Our Ref: EN010132

Date: 18 April 2023

Application by West Burton Solar Project Limited for an Order Granting Development Consent for the West Burton Solar Project

Advice following issue of decision to accept the application for examination

**Land Plans**  
Sheet 1 of 10  
Revision C

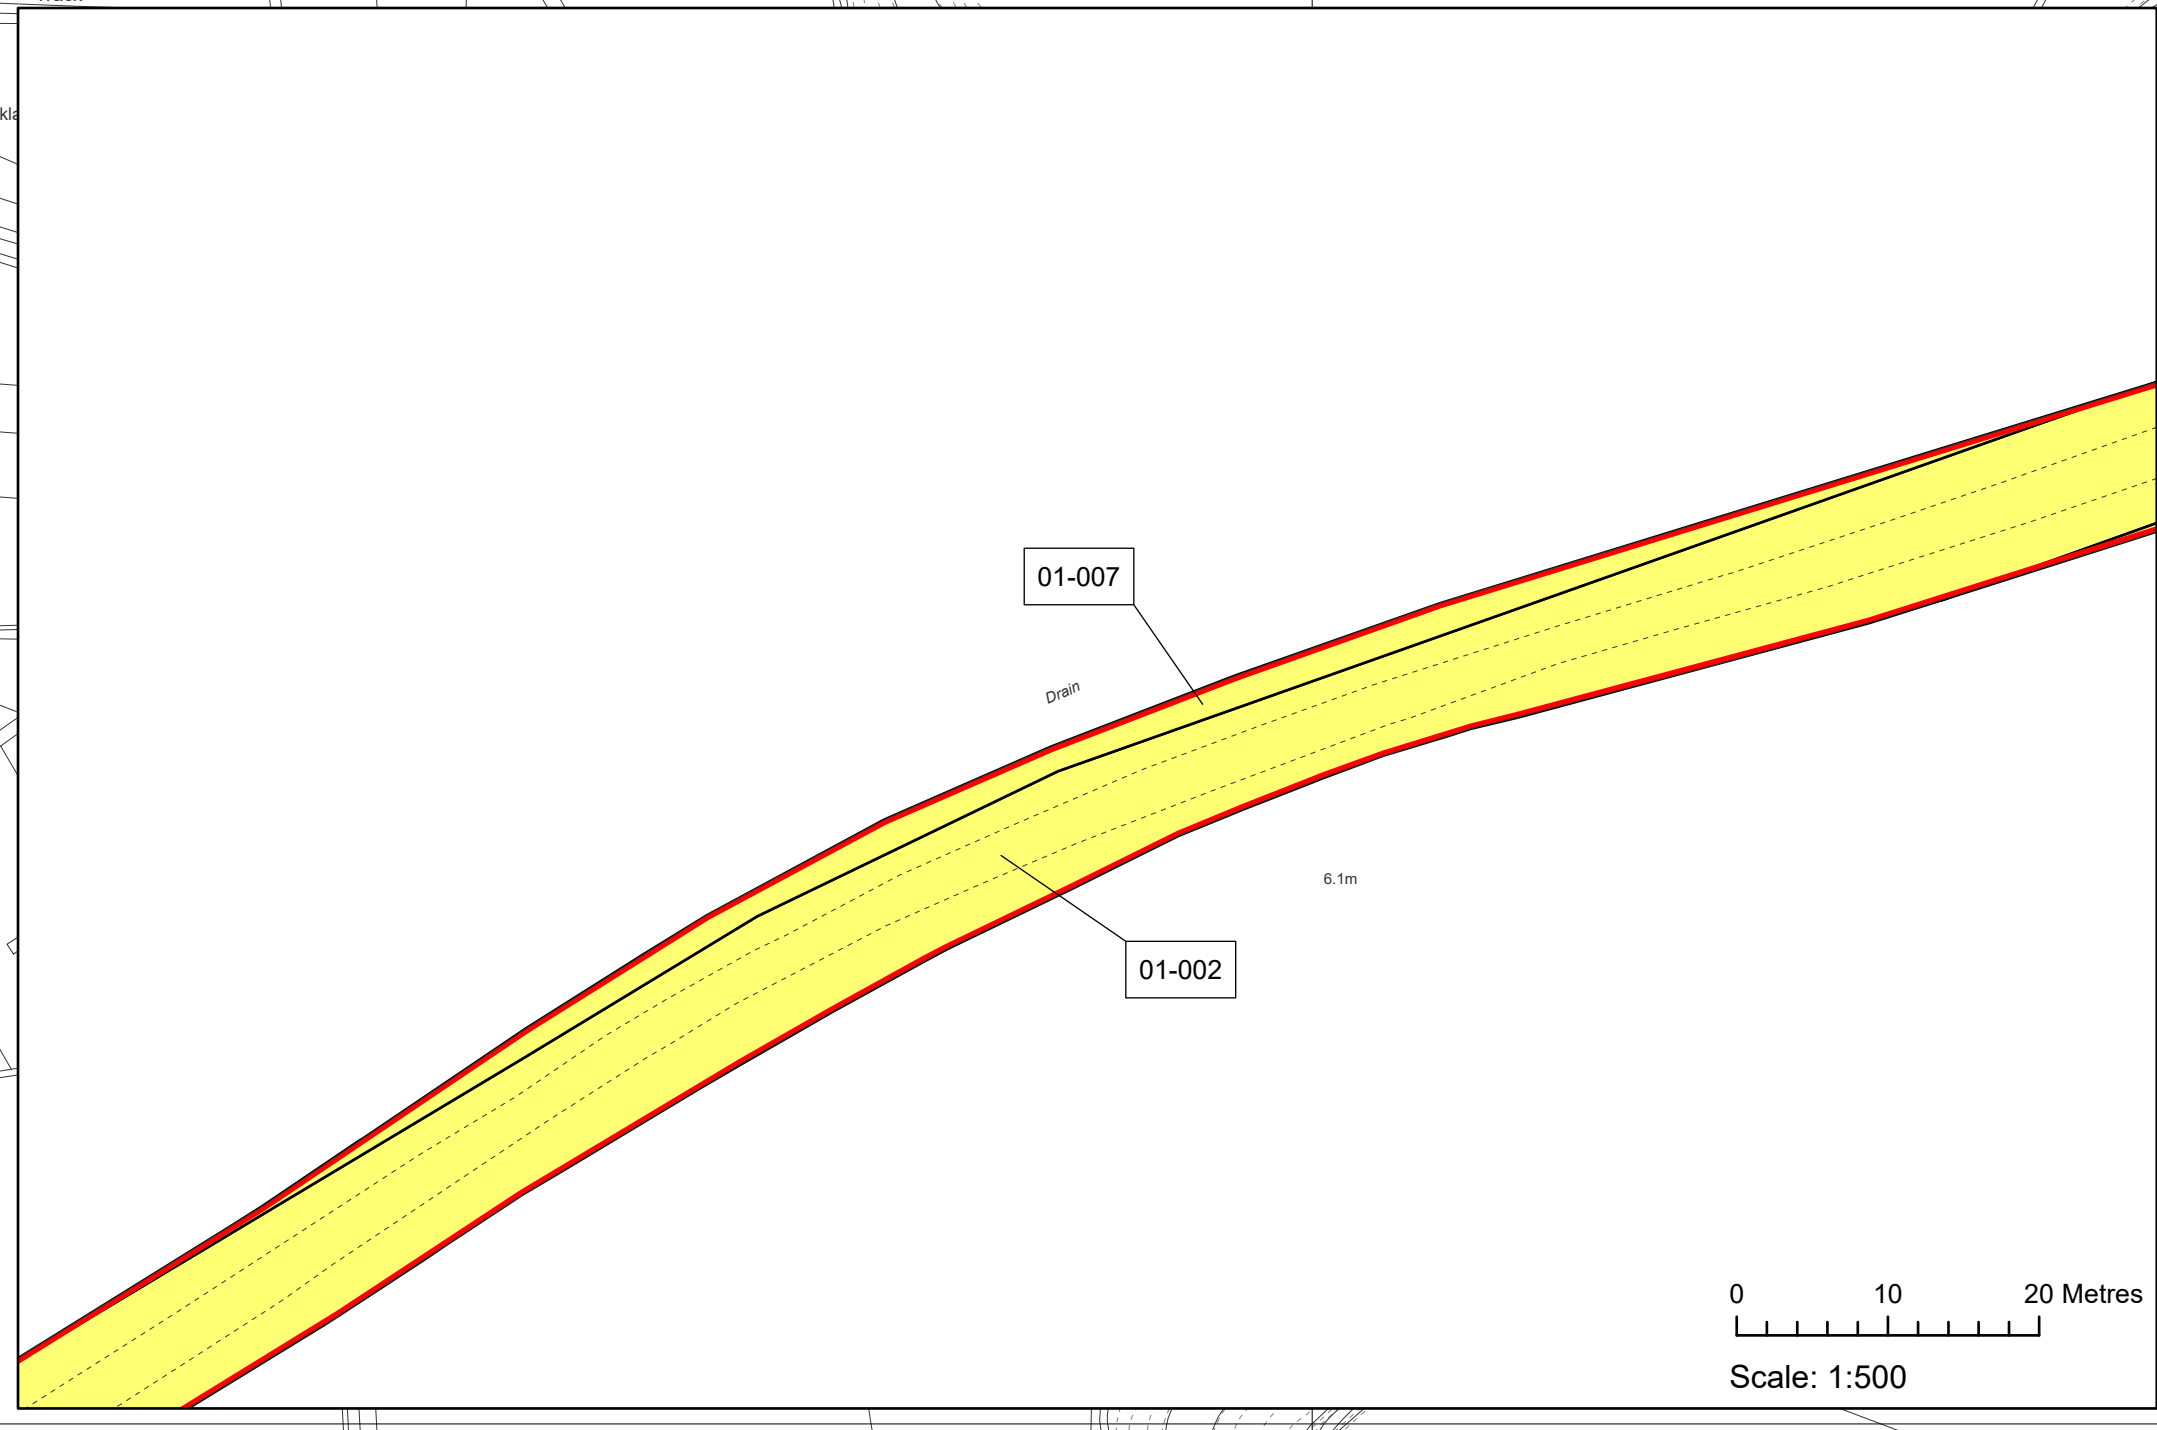
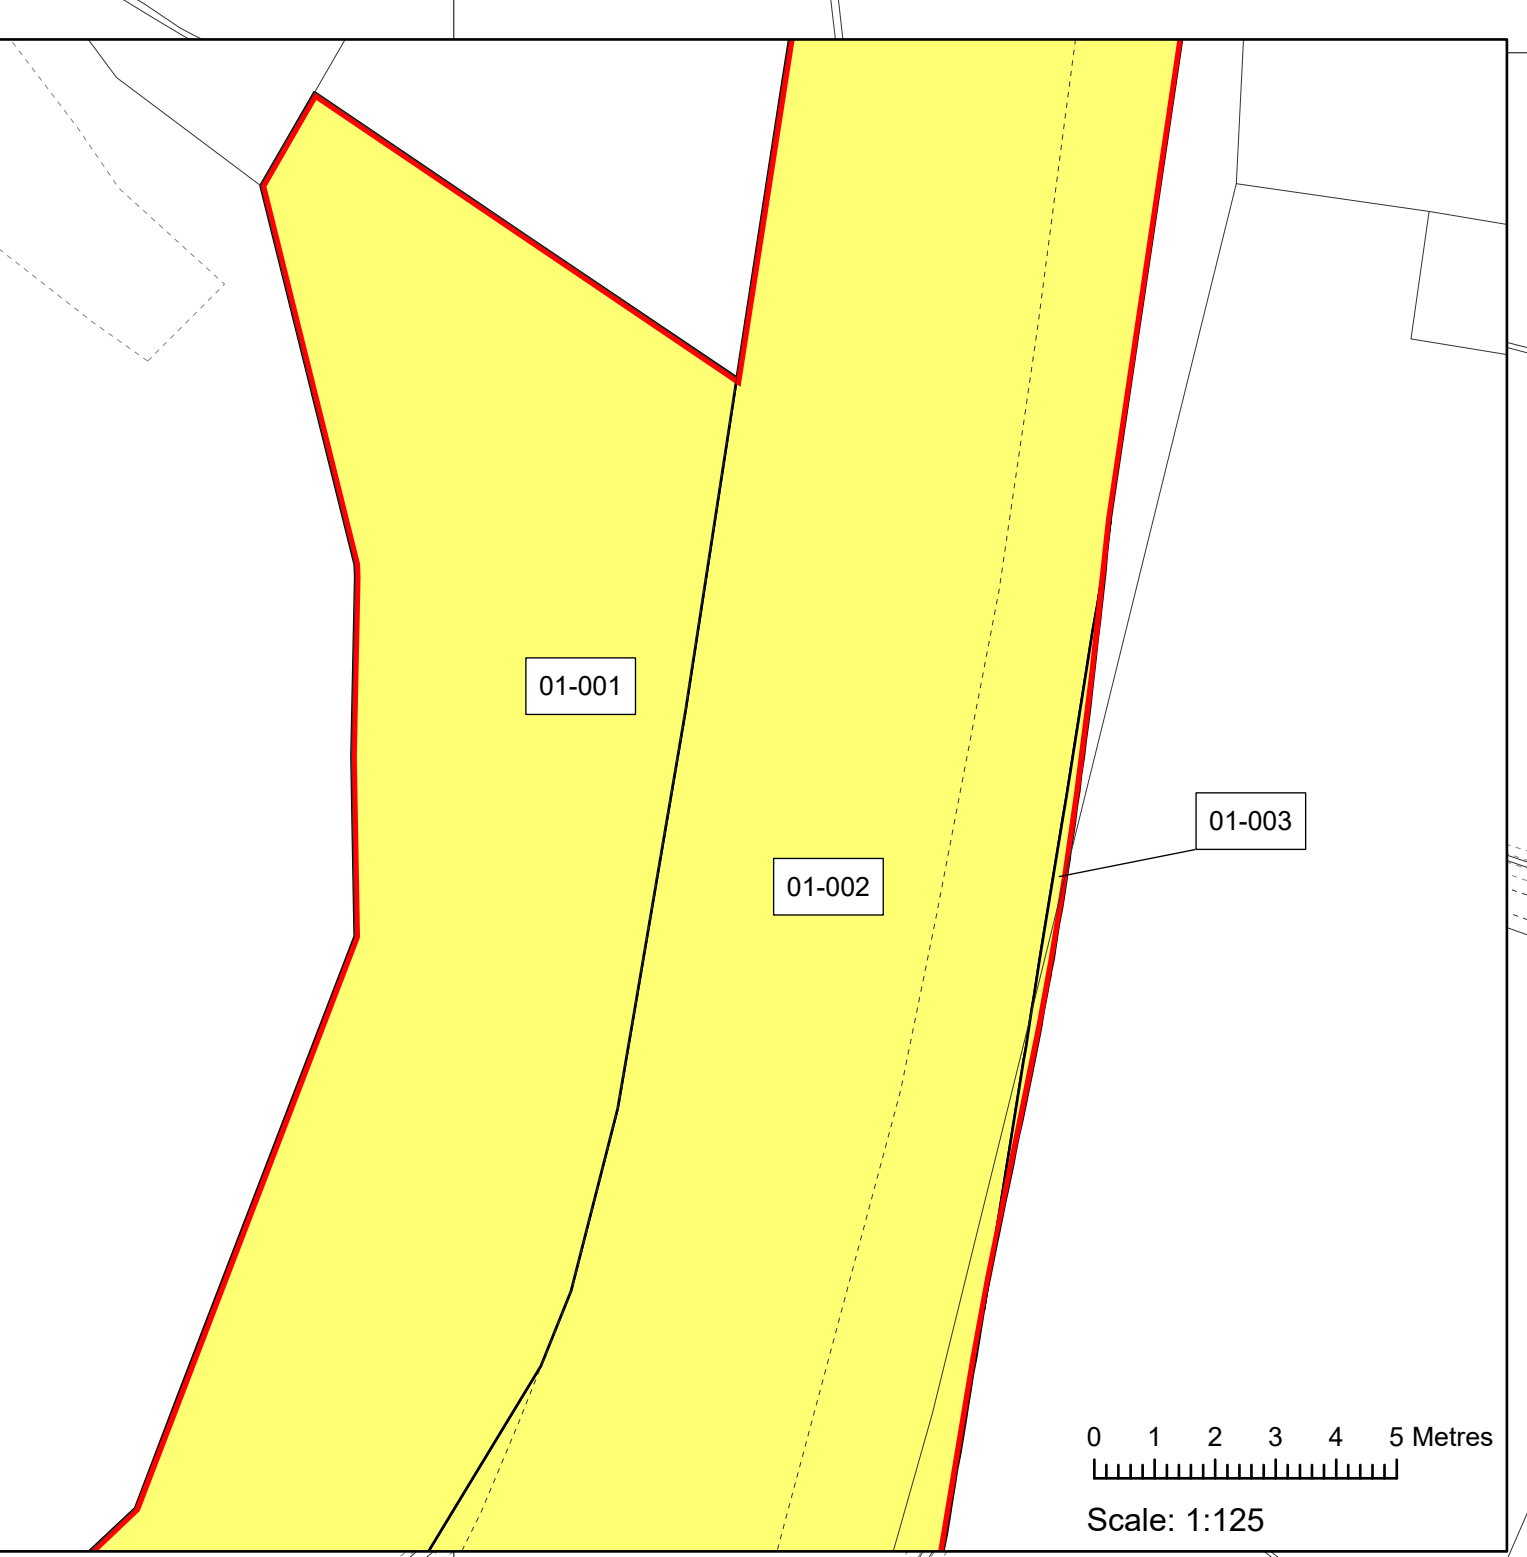
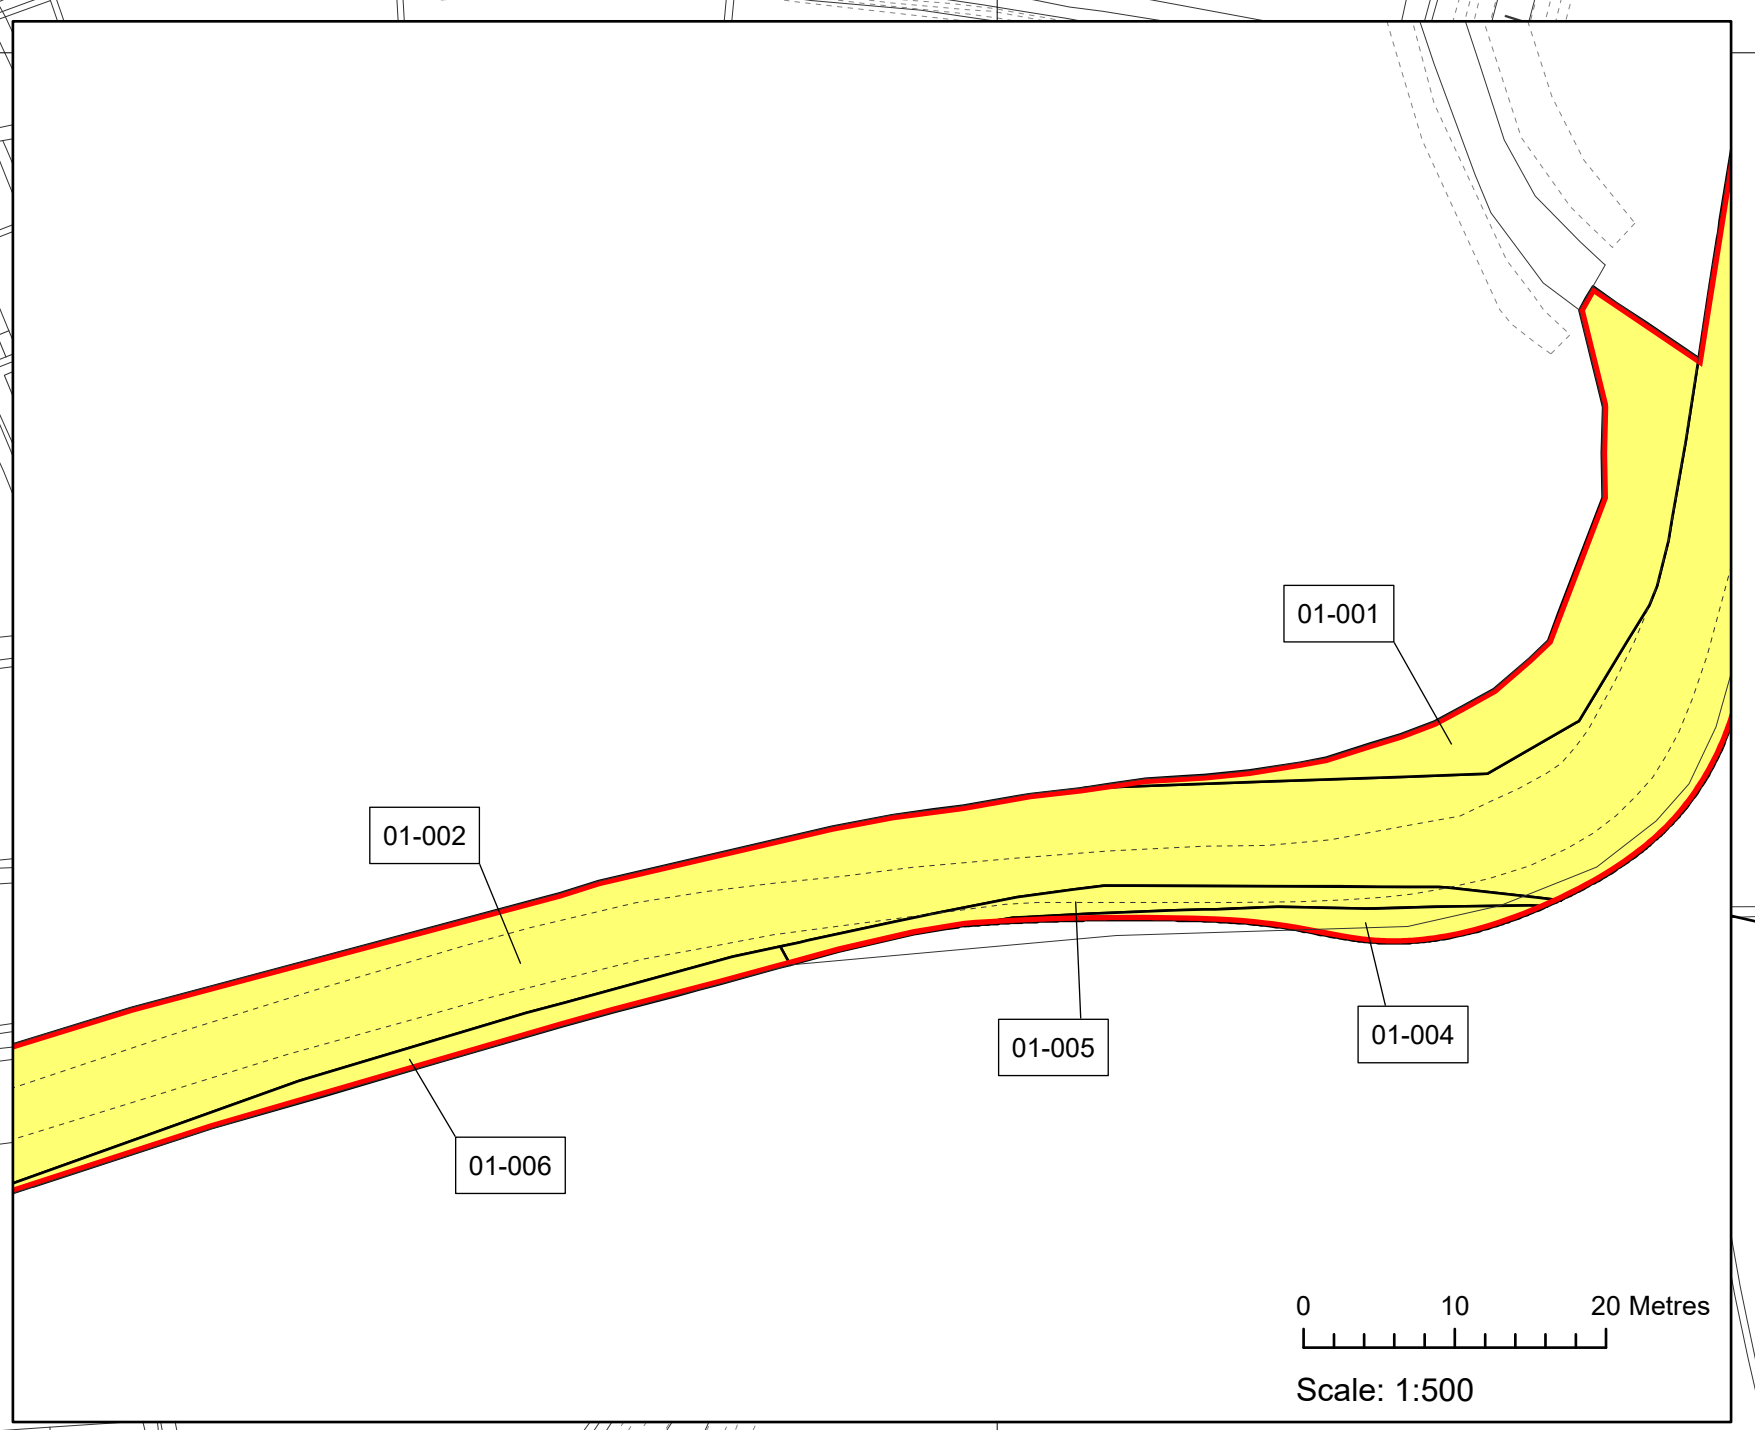
A north arrow is not present and see comment below relating to Book of Reference.
